RE: **La Pasada Addition**
2206 4th NW
Grading and Drainage Plan
Engineer's Stamp Date 8/13/18
Hydrology File: H14D089

Based on the submittal received on 8/13/18, the Grading and Drainage Plan cannot be approved until the following are corrected:

C-101

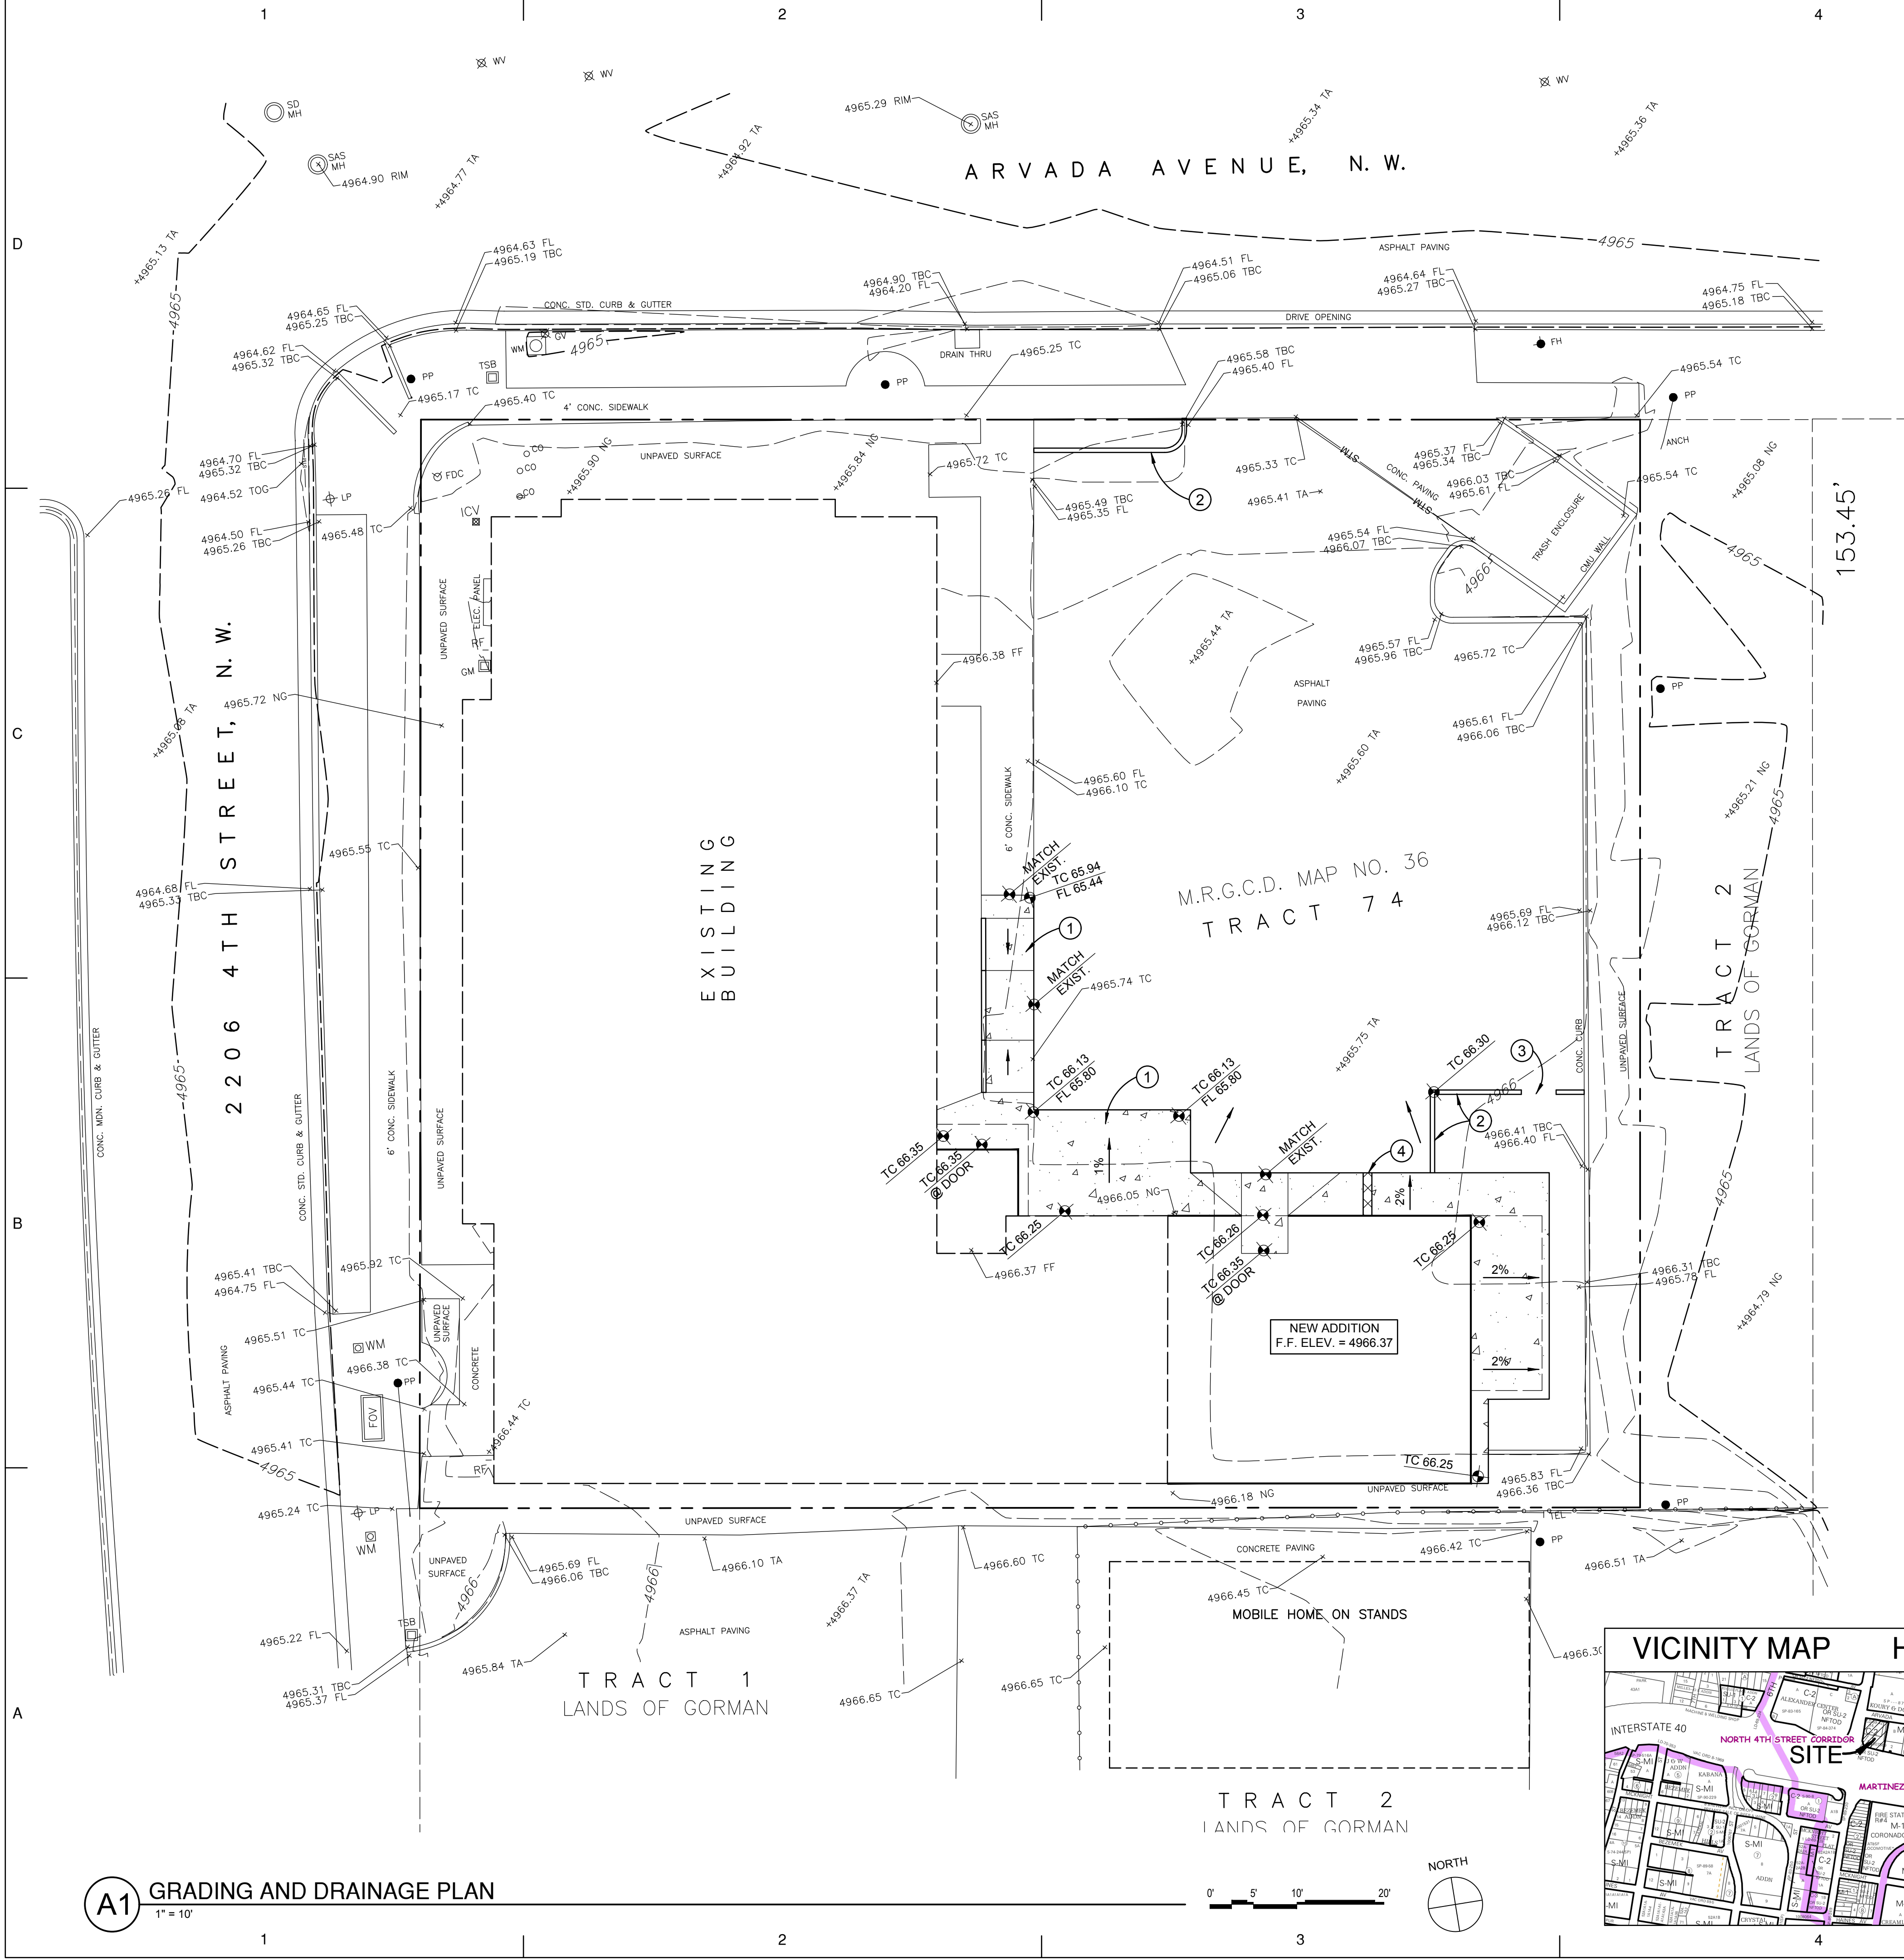
2. Payment of Fee-in-Lieu is required for the areas of new/redevelopment construction only; i.e. the new addition and the new sidewalk area. The amount required is then calculated as: (sf of the addition +sf of the rebuilt sidewalk) * (.26"/12) * (\$8/cf).

3. Is the parking lot being repaved? If so, that area needs to be included in the work and calculations as well. Mill and overlay is not considered a re-pave.
